From: Anita Gardner <Anita.Gardner@arun.gov.uk>
Sent: 03 June 2020 13:35
To: Planning.Responses <Planning.Responses@arun.gov.uk>
Subject: FW: LY/4/20/PL Barn at Broomhurst Farm, Lyminster

From: Info @ Folkes Architects [REDACTED]
Sent: 03 June 2020 11:14
To: Anita Gardner <Anita.Gardner@arun.gov.uk>
Cc: D HARRIOTT [REDACTED]
Subject: RE: LY/4/20/PL Barn at Broomhurst Farm, Lyminster

Please find attached a copy of the revised site plan, drawing number 20011/2.01 revision C and drawing 2.02 revision A. I would be grateful if you could substitute these for the previous versions.

DATE 11.02.2020	SCALE 1:100	DRAWN BY MF
JOB NO. 20011		CHECKED BY _
DRAWING NO. 2.02		REVISION A

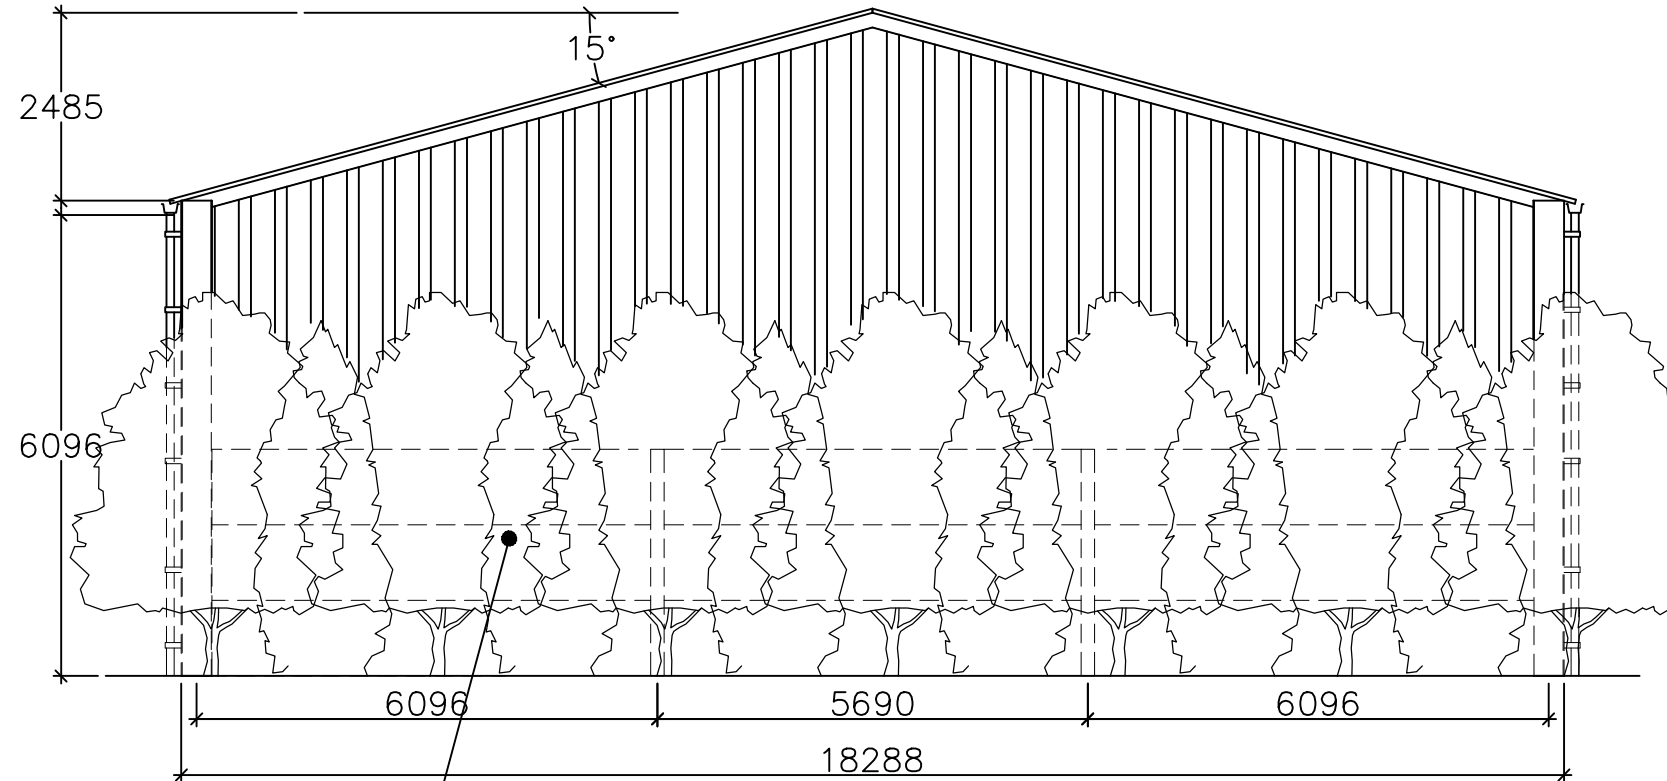
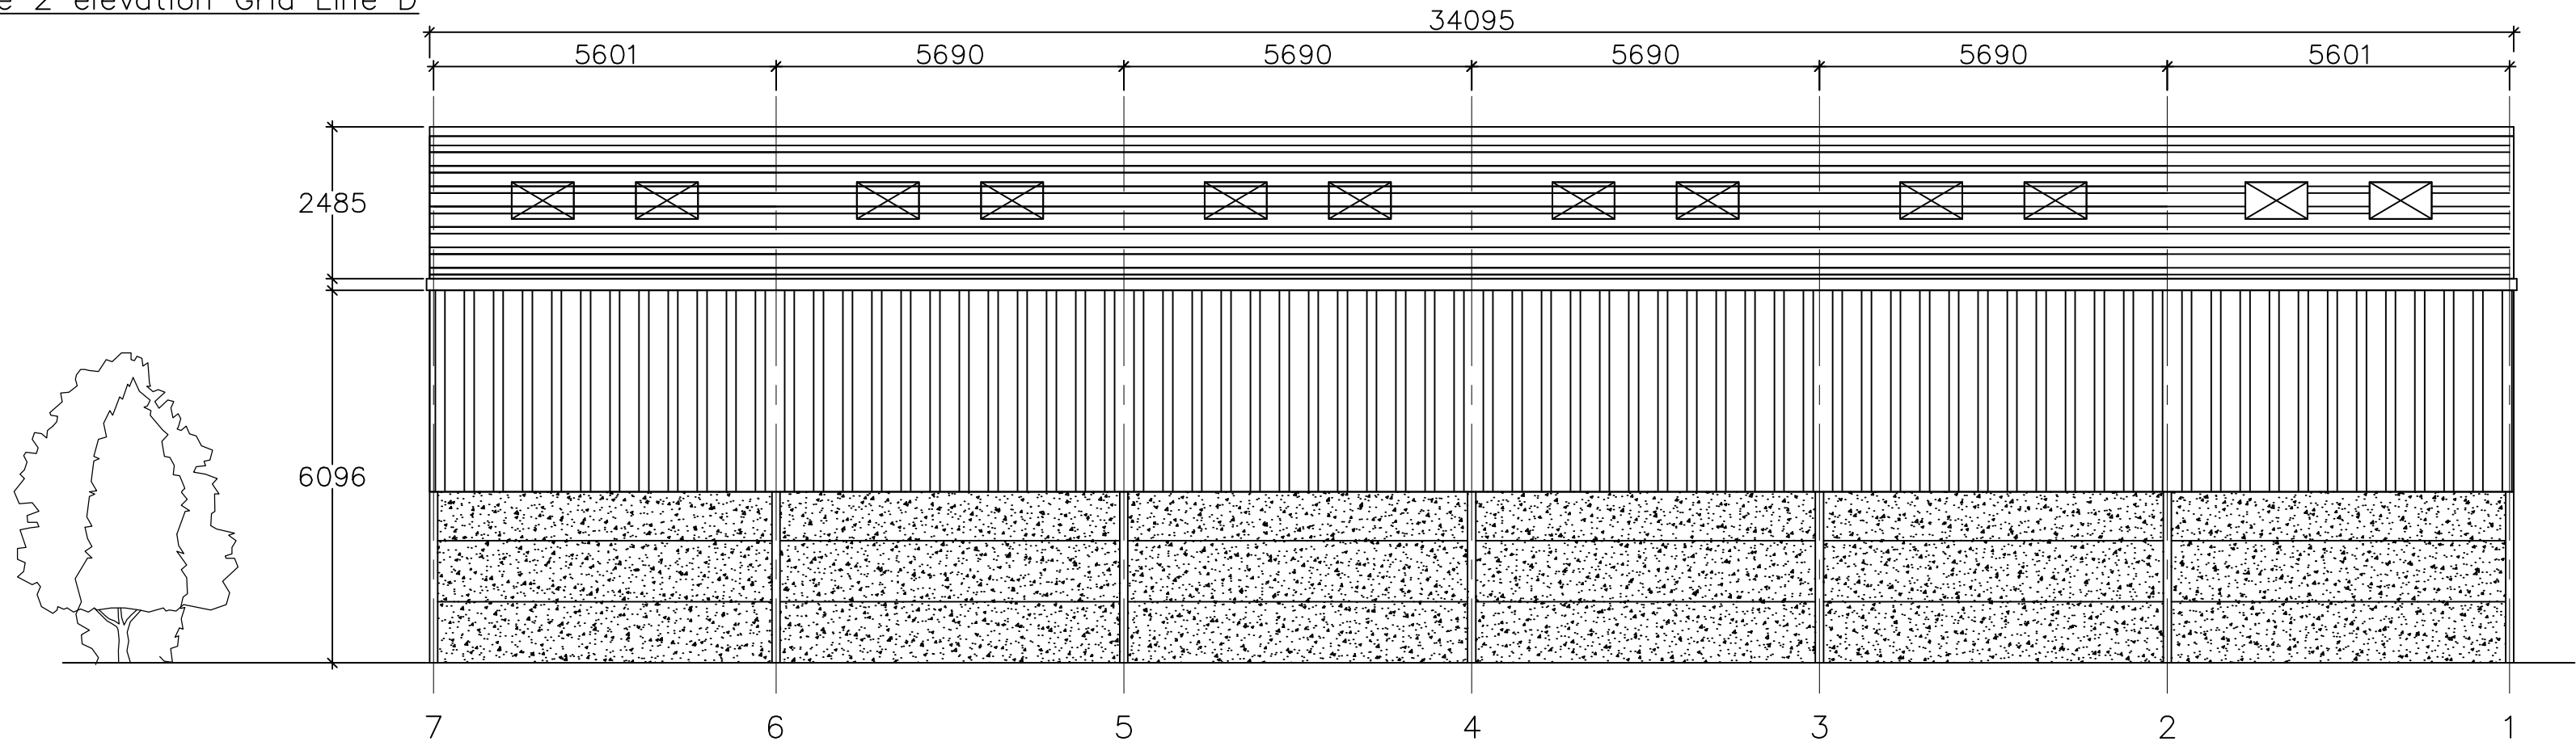
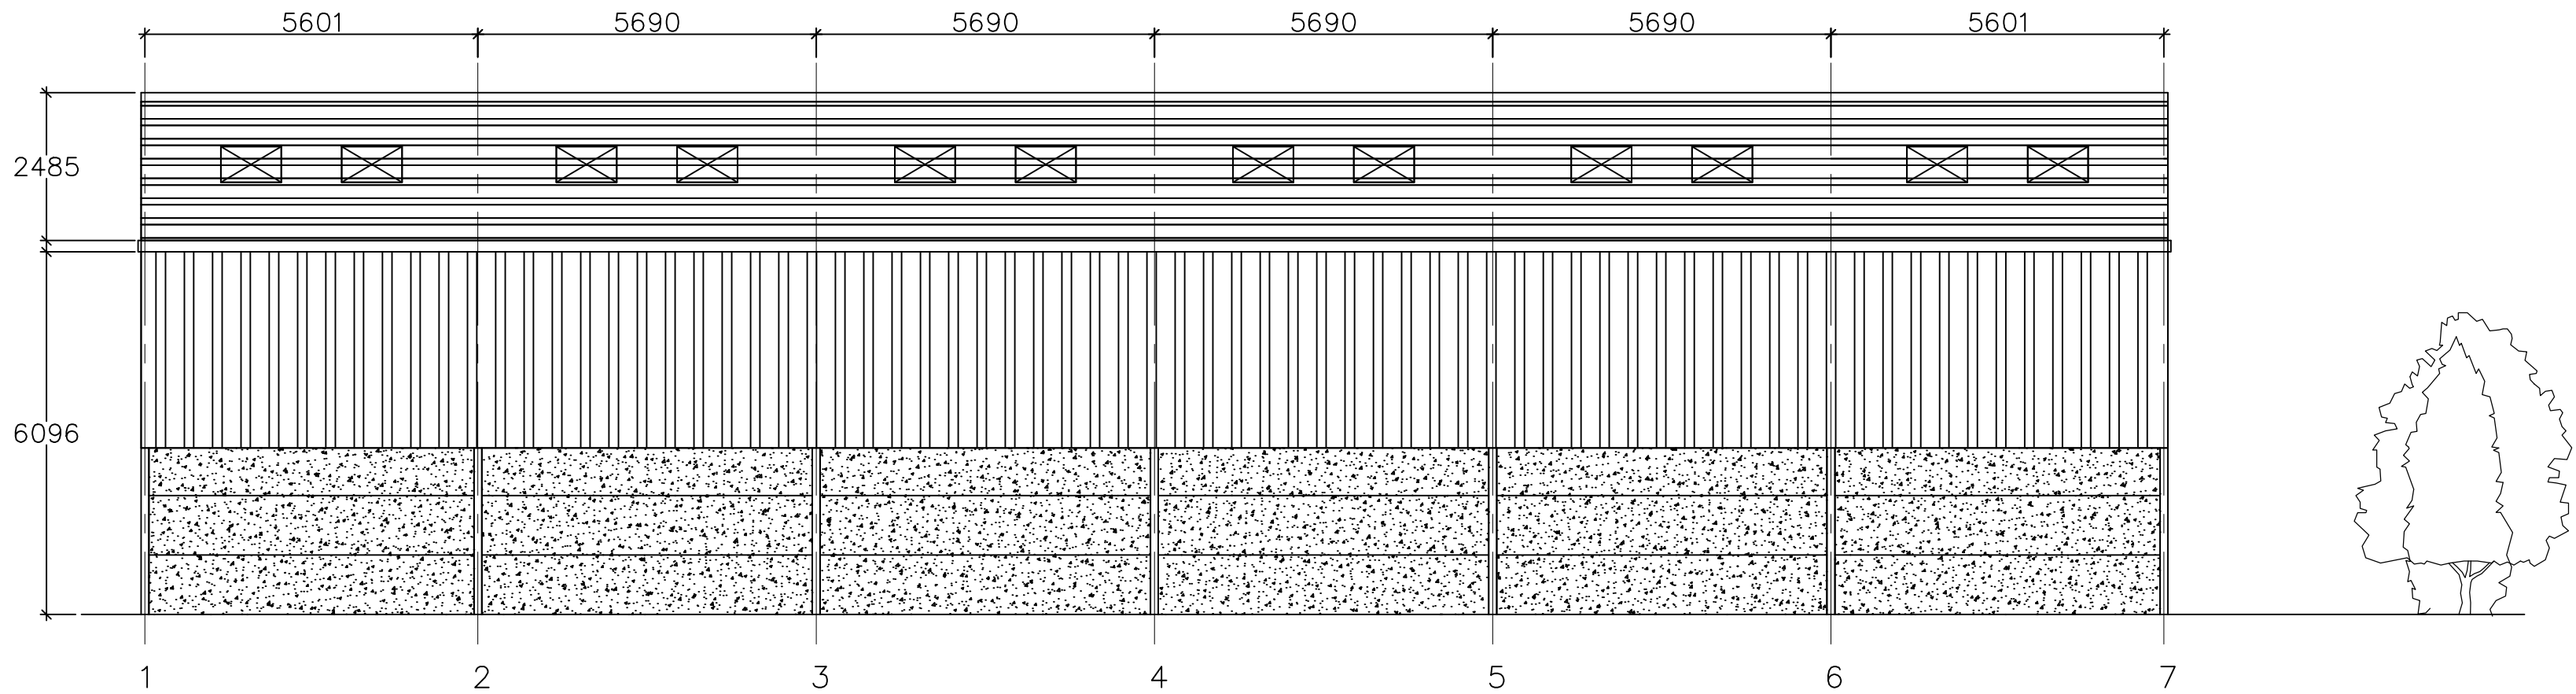
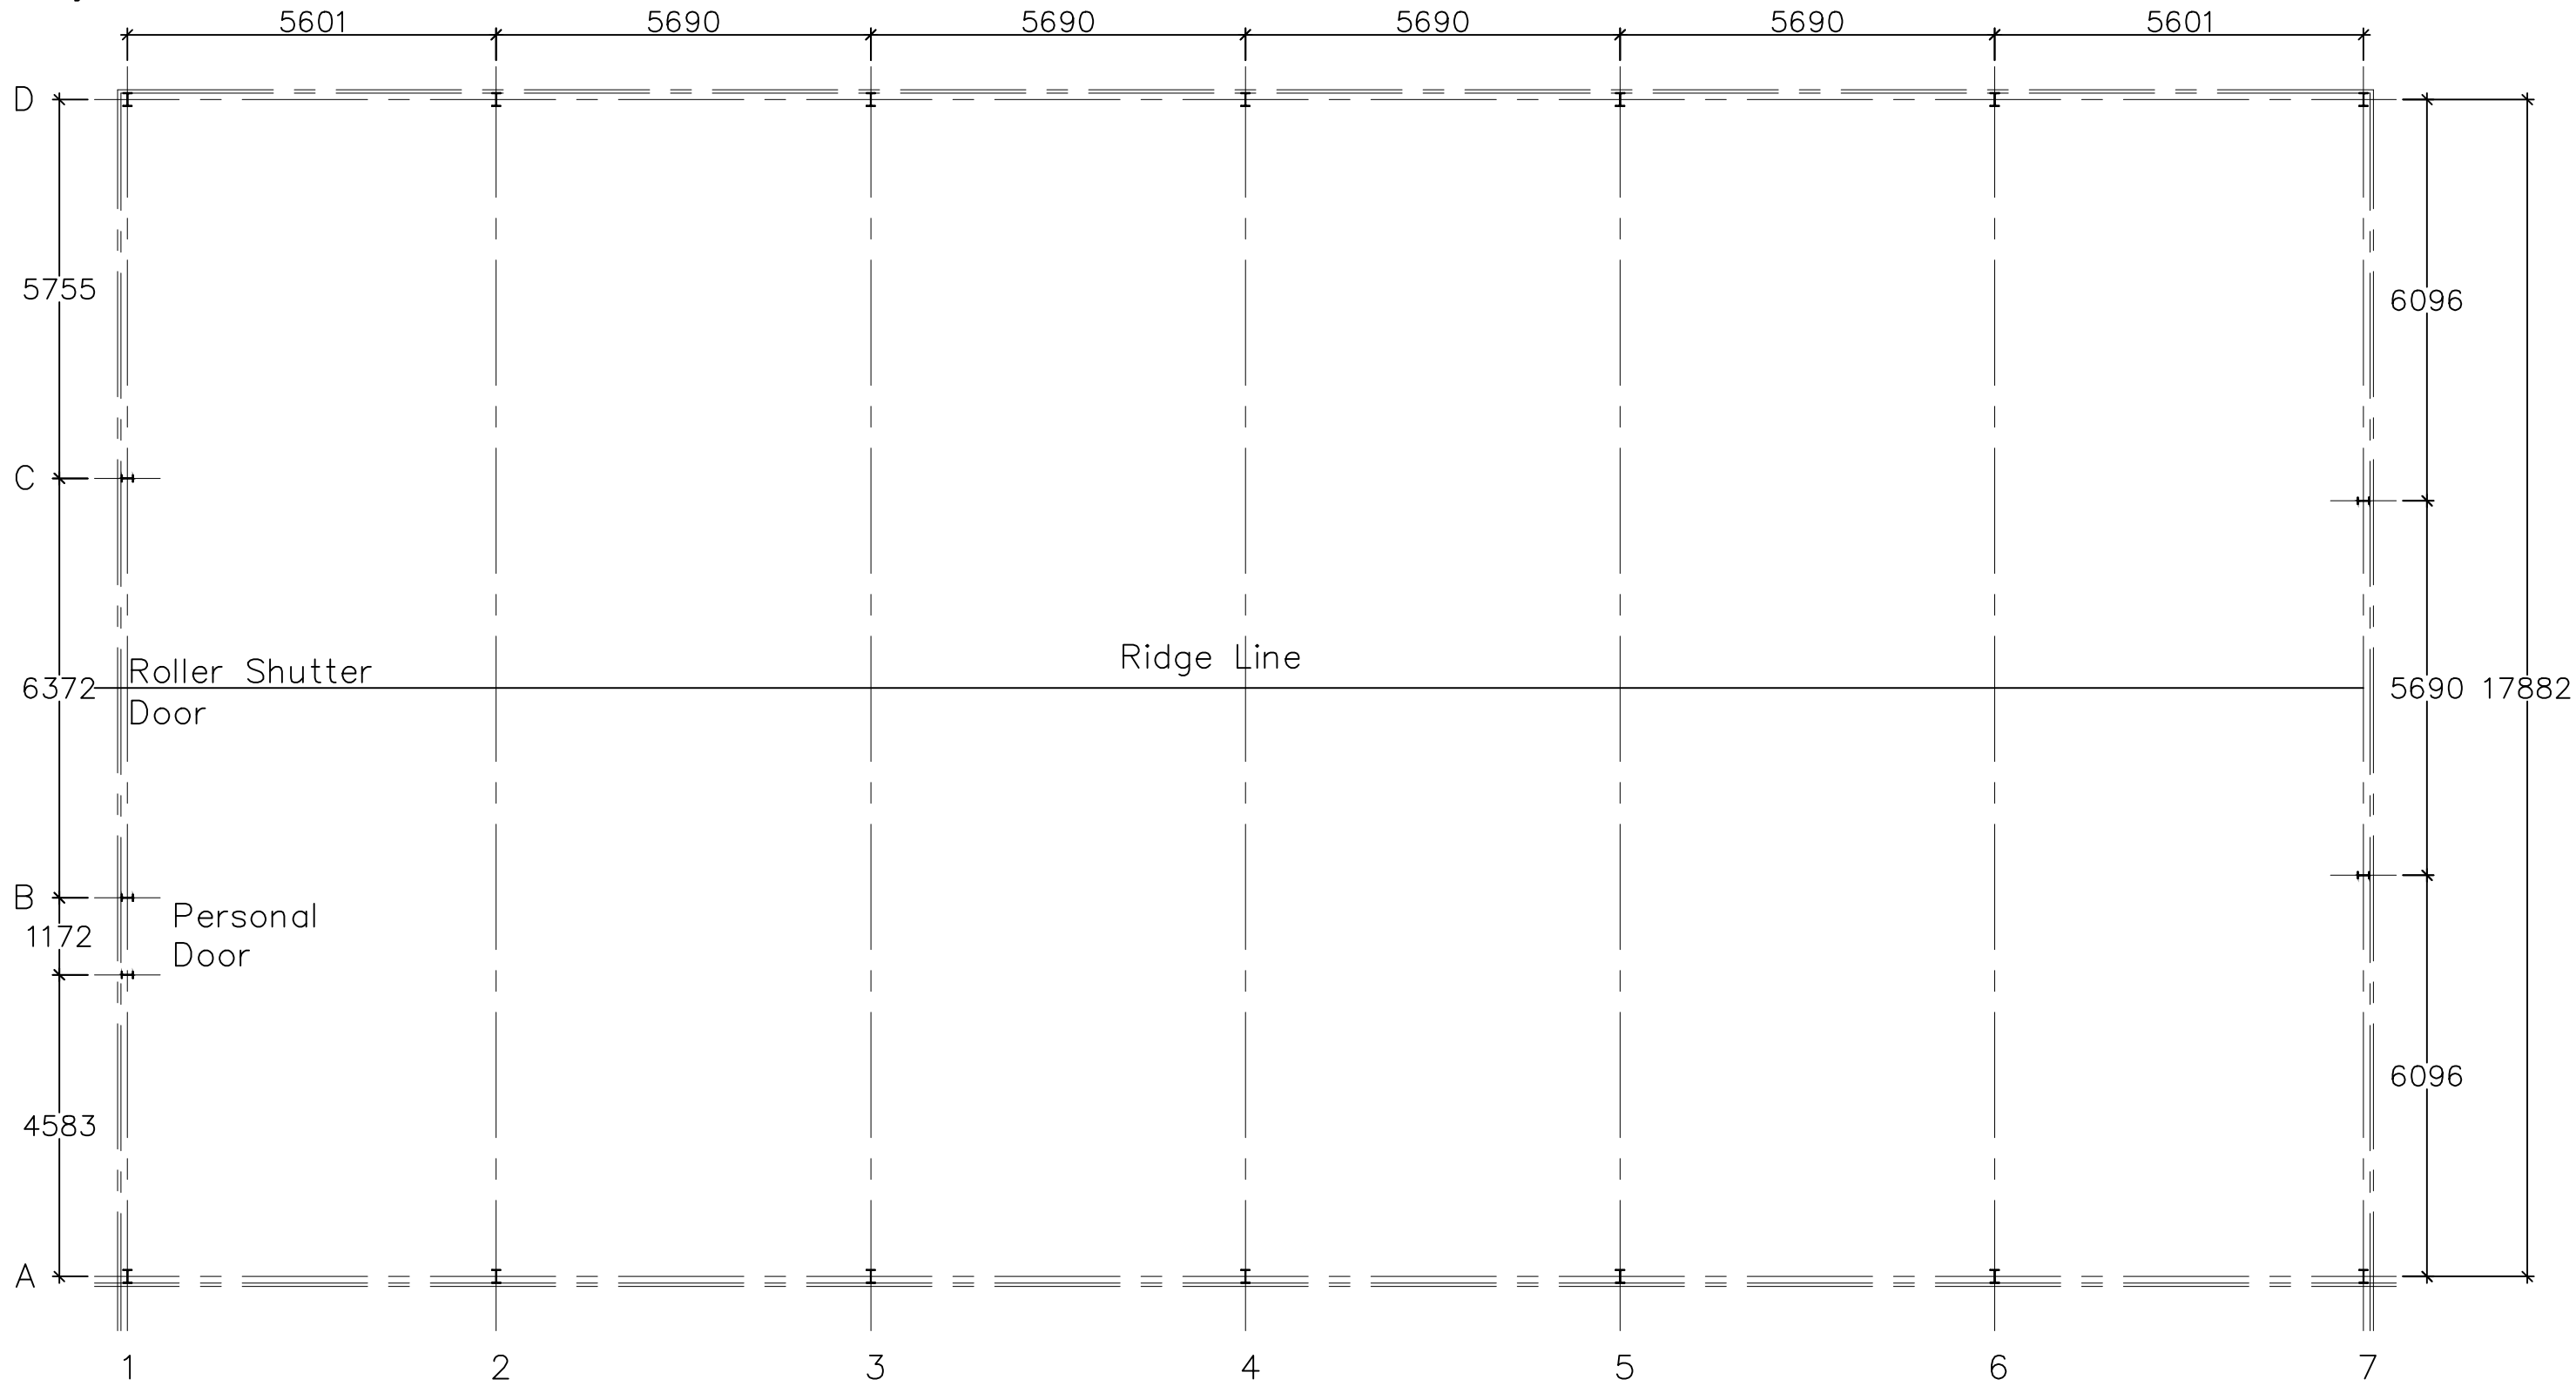
Please can you let me have a revised site plan and elevation plan indicating native tree planting along the southern boundary as discussed, by Wednesday next week?

I have reconsulted the Ecologist based on the details submitted and await her response. In the meantime I would appreciate receipt of a revised site plan indicating the provision of native planting along the south elevation of the barn.
